Sydney Metro (Chatswood to Sydenham) SSI 7400 Notice of Exhibition

Thank you for providing the Port Authority of NSW (Port Authority) the opportunity to comment on the Sydney Metro proposal and to provide advice on any recommended conditions of approval. The Port Authority has reviewed the EIS, particularly in the context of the matters raised in our submission (dated 11 December 2015) to the request for Secretary's Environmental Assessment Requirements.

Figure 7-2 Indicative locations of ground improvement work

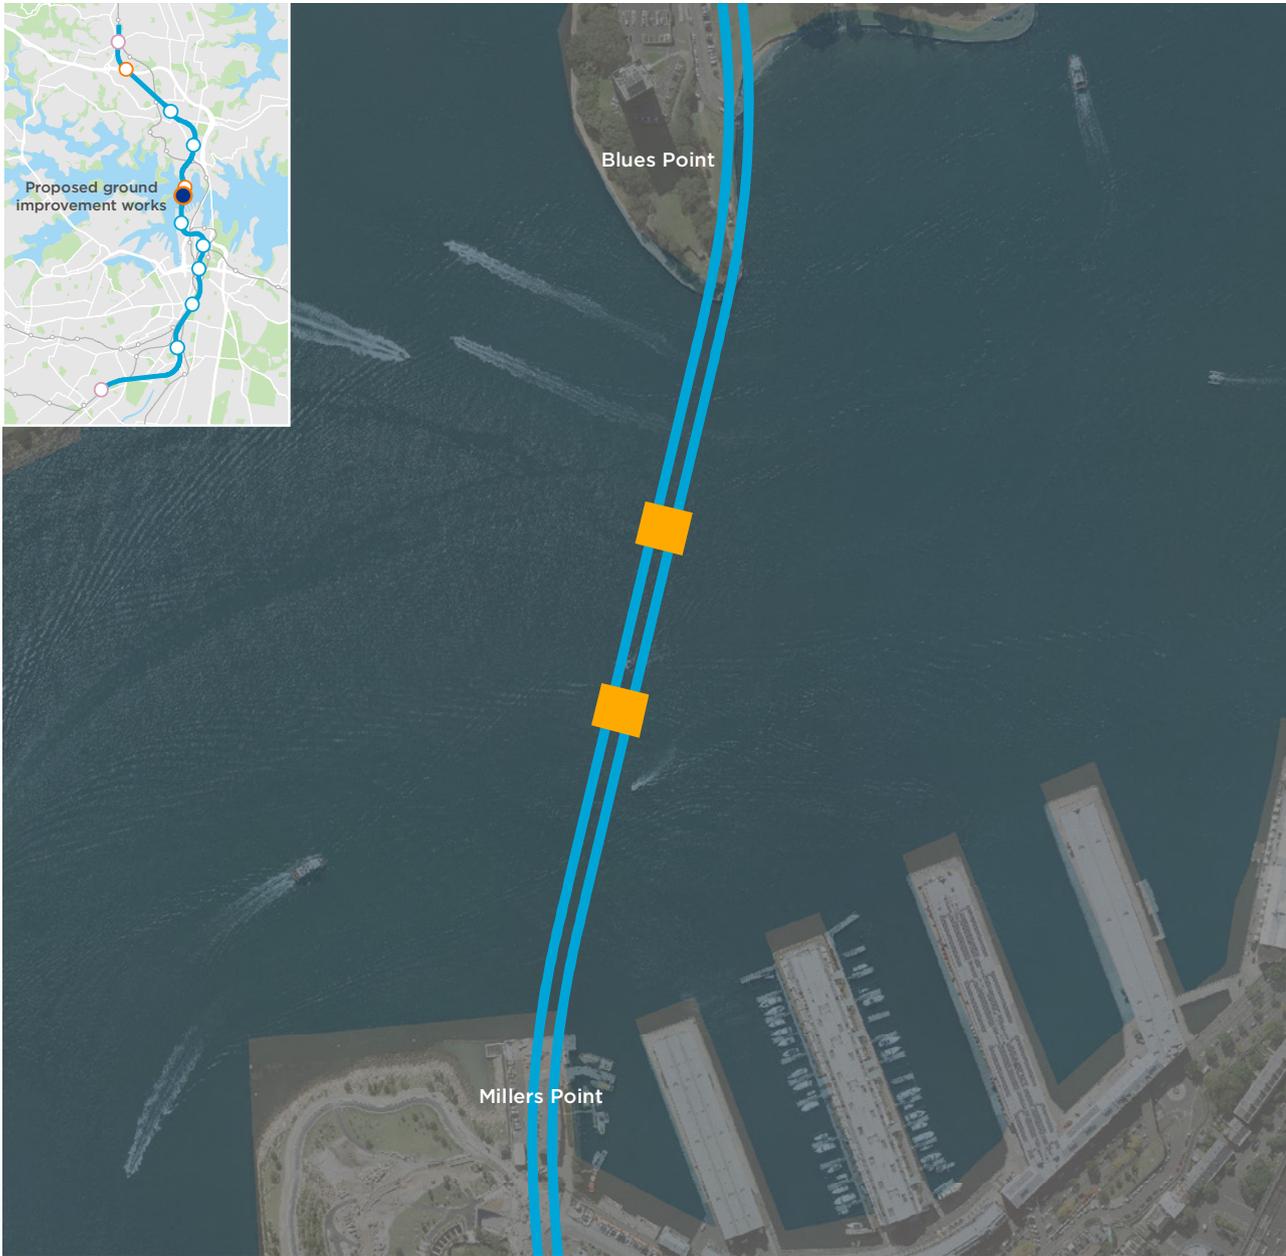
It is understood that the proposed Sydney Harbour ground improvement works, depending on the methodology selected, may involve the placement of barges in the shipping channels. Although a commitment has been made to consult with the Harbour Master to ensure shipping channels are maintained during these works, it is noted that the EIS focusses on shipping traffic to Gore Bay. Shipping traffic to Glebe Island and White Bay must also be considered as clear passage to Darling Harbour needs to be maintained for cruise ships, bulk carriers and other ad hoc vessels. Shipping movements to both Gore Bay and via Darling Harbour to Glebe Island and White Bay occur year round and from approximately October to March, movements in and out of Darling Harbour exceed those for Gore Bay, with up to 4 cruise ship movements per day and regular bulk carrier movements. Therefore, it is considered that

further consultation with the Port Authority of NSW is required during the design development of the Sydney Harbour sediment ground improvement works with regard to potential impacts on the shipping channels. Any solution must be carefully planned and/or coordinated to ensure that shipping access to and from Gore Bay and Glebe Island and White Bay via Darling Harbour remains open and that any barges do not impede the safe navigation of vessels in these areas. Until this matter is investigated in more detail, the Port Authority also requests that the ground freezing option for the proposed ground improvement works, which would seem to not require the placement of barges in the shipping channels, needs to be maintained as an option.

Figure 7-13 Barangaroo Station construction site indicative layout

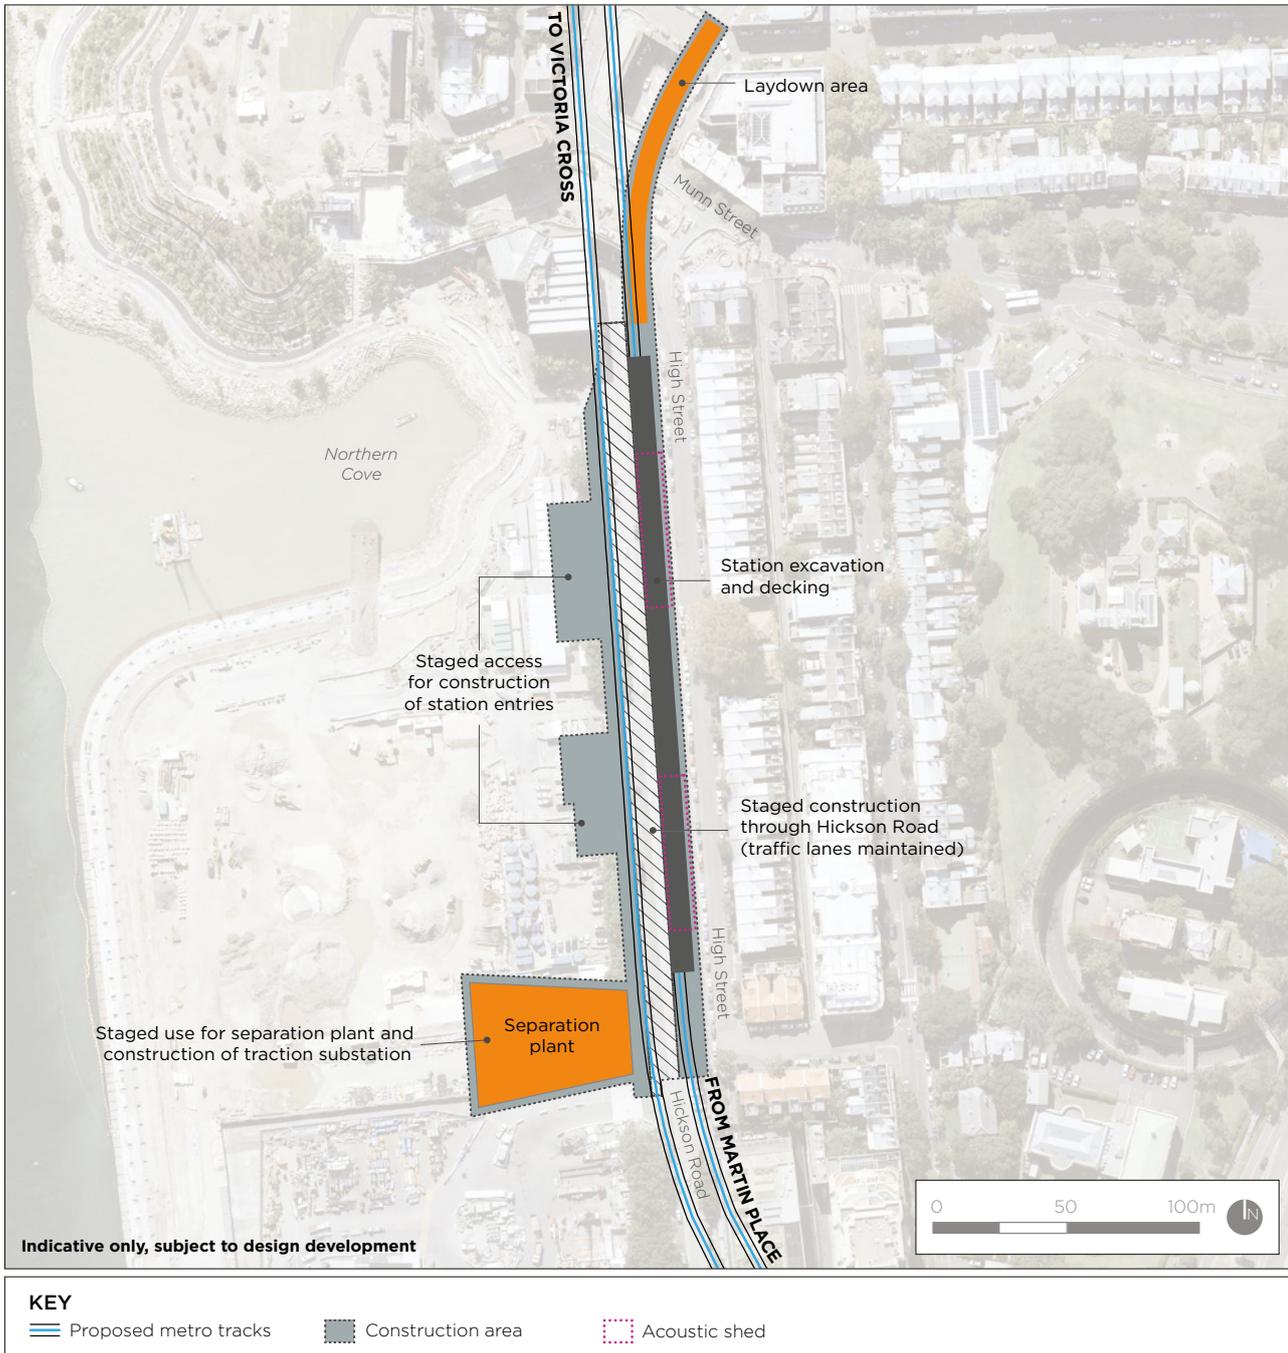
As indicated in the Port Authority's response to the request for SEARs, the Port Authority is concerned about construction impacts from proposed works in the vicinity of Barangaroo on Hickson Road, which provides access to the Overseas Passenger Terminal (OPT) for providoring semi-trailer trucks (19m articulated trucks) and passenger coaches. It is acknowledged that a commitment has been made in Section 8.4.13 of the EIS to consult with the Port Authority throughout the construction phase, however mitigation measure T1 does not include the Port Authority for ongoing consultation. The EIS also indicates that coach and delivery vehicle movements to the OPT occur over a short duration at arrival and departure of a ship. This is not correct as 19m articulated trucks, coaches and other delivery vehicle traffic to the OPT occurs throughout the morning and into the mid-afternoon. Therefore, to ensure that adequate consultation and coordination occurs, the Port Authority requests that the Port Authority is specifically noted in either an amended mitigation measure T1 or in the conditions of approval for ongoing consultation to minimise traffic and transport impacts on the OPT during construction.
